**SSD 6011 - Mixed use residential development within the South West Plot**

**Submission by:**

**Urs Schaller and Channa schaller**

**30 July 2013**

## Winter Solstice (21<sup>st</sup> June)

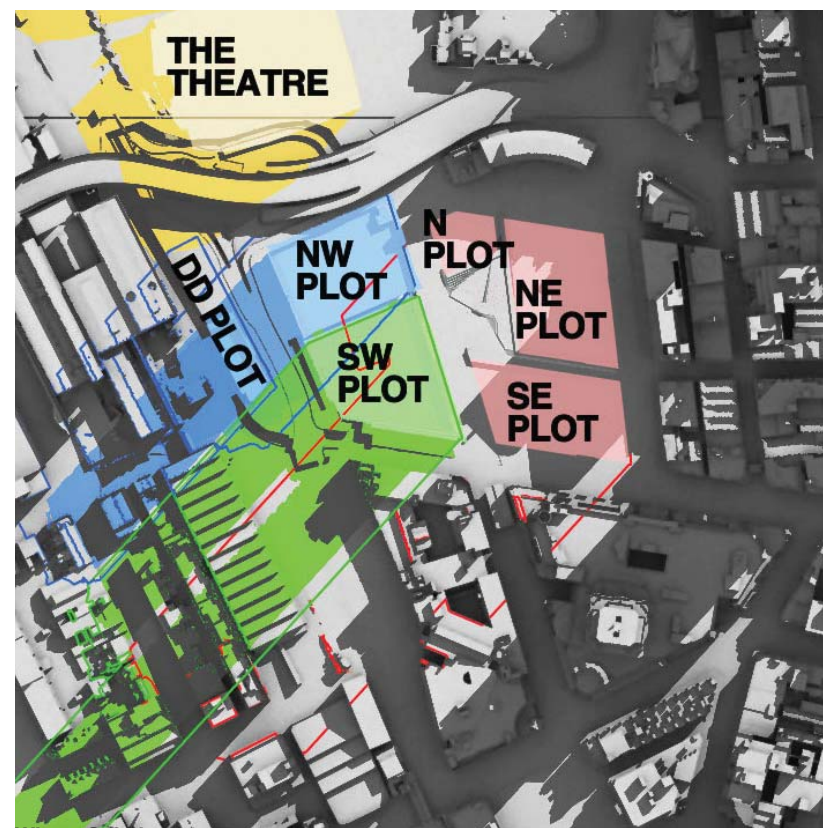
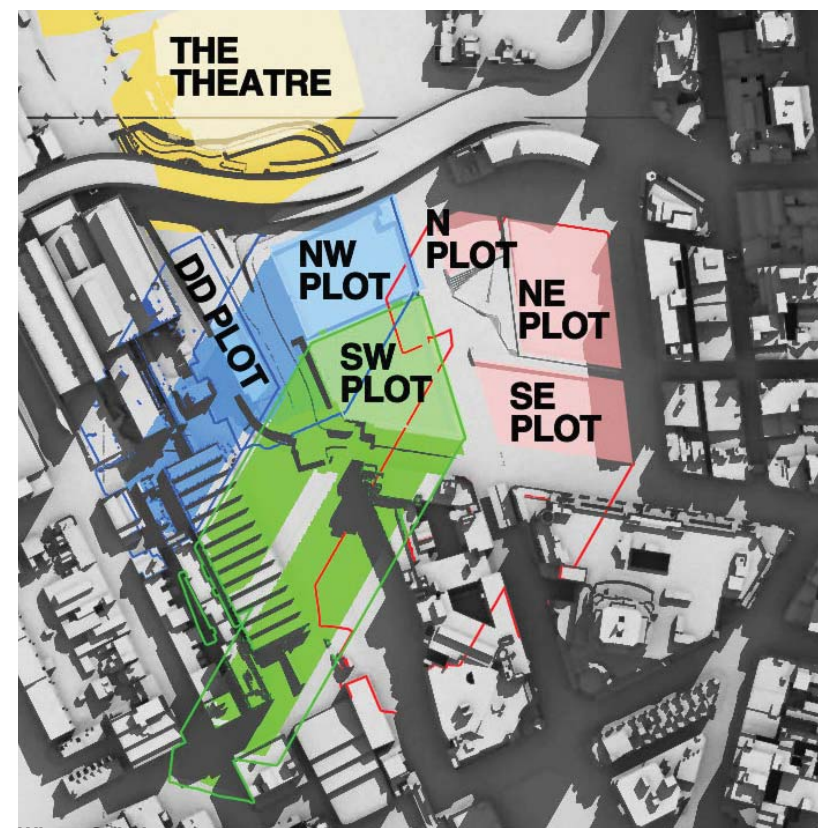
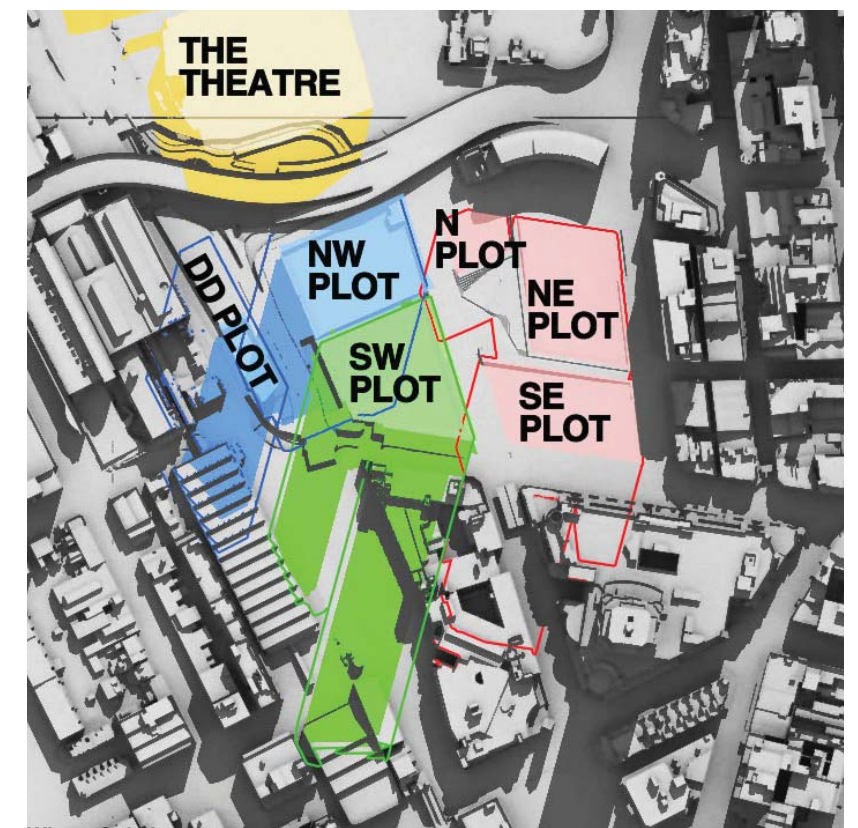
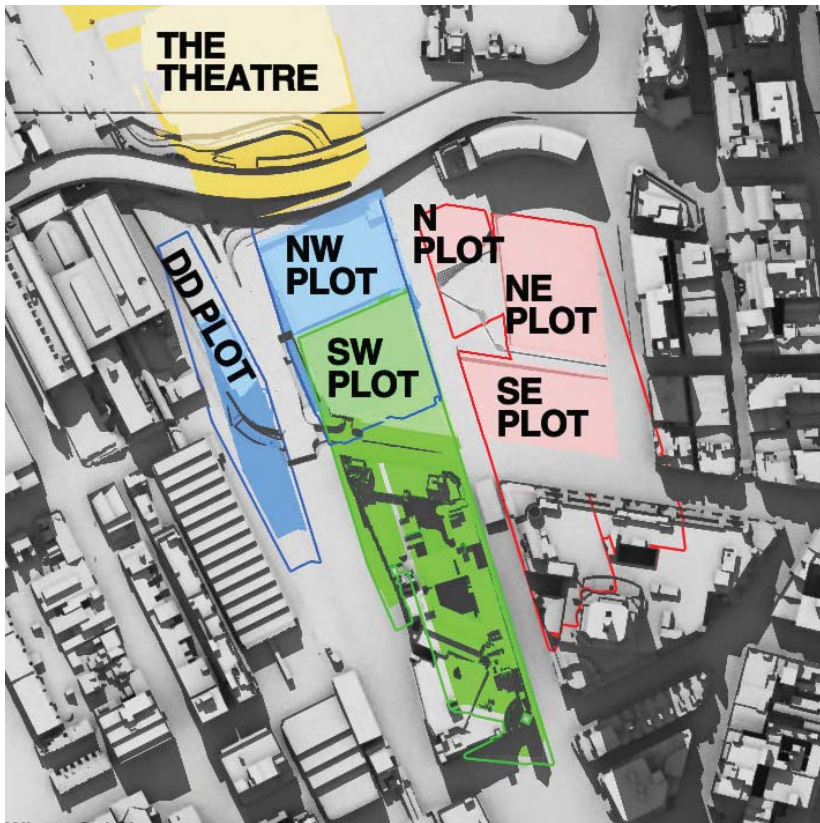
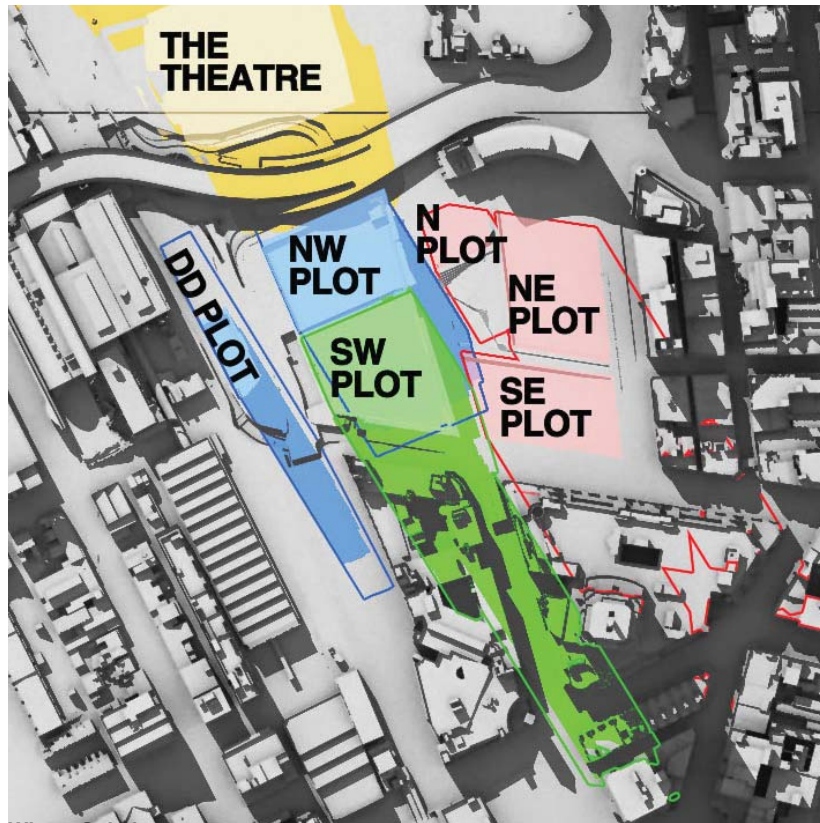
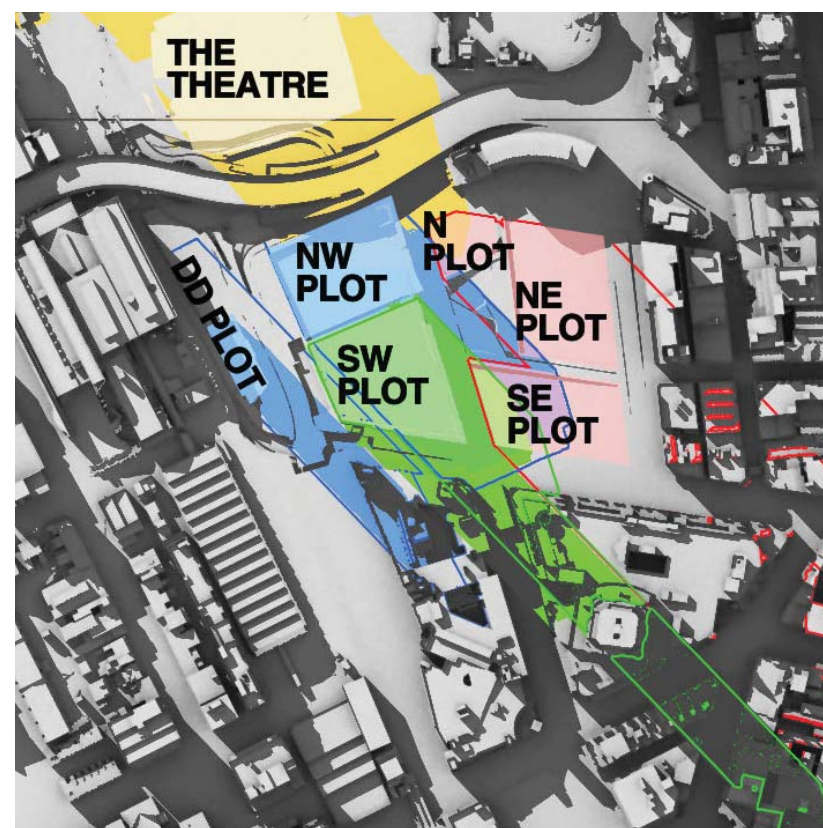
We refer to the shadow diagrams in SSD5878, Appendix H. Supplementary Design Report, Section 6. Amendments, Winter solstice - 22 June. This is not 21 June, but there would be no noticeable difference.

At 9am, 10am and 11am the west façade is totally in shadow due to other parts of The Peak building itself.

At 12pm there is still substantial existing shadowing on the west façade caused by the irregular shape of the west facade.

At 1pm the existing shadowing has been substantially removed, but not totally removed.

It can be concluded that some single aspect apartments on the west façade and some south-west dual aspect corner apartments currently receive less than 2 hours direct sunlight to habitable rooms and 50% of the private open space between 9am and 3pm on 21 June.

By 2pm the existing shadowing has been totally removed, but that is too late to achieve two hours of direct sunlight before 3pm.

At 9am, 10am and 11am the west façade is totally in shadow due to other parts of The Peak building itself.

At 12pm there is still substantial existing shadowing on the west façade caused by the irregular shape of the west facade.

At 1pm the existing shadowing has been substantially, although not entirely, removed. However, overshadowing of lower levels of the west façade by the concept proposal parameter plan shadows for the N,NE and SE plots has already started.

By 2pm the existing shadowing has been totally removed. However, overshadowing of the west façade by the SSDA4 and SSDA5 buildings has appeared and risen further up the west façade than the concept proposal parameter plan shadows for the N,NE and SE plots, which is still present.

At 3pm, the proponent states correctly that 45-45% of the western façade is overshadowed by the SSDA4 and SSDA5 buildings.

It can be concluded that, as a result of combination of the proposed development with existing shadowing of the west façade, some single aspect apartments on the west façade and the south-west dual aspect corner apartments which currently receive less than 2 hours direct sunlight to habitable rooms and 50% of the private open space between 9am and 3pm on 21 June will suffer additional overshadowing. It is beyond our skills to count the number of such apartments. We note that the proponent has made no attempt to do so.

Rather than counting the number of units which will not meet the DCP guidelines, the proponent attempts to trade-off direct sunlight at 4pm for lack of direct sunlight during the period 9am to 3pm. There is no provision in the DCP guidelines for such a trade-off.
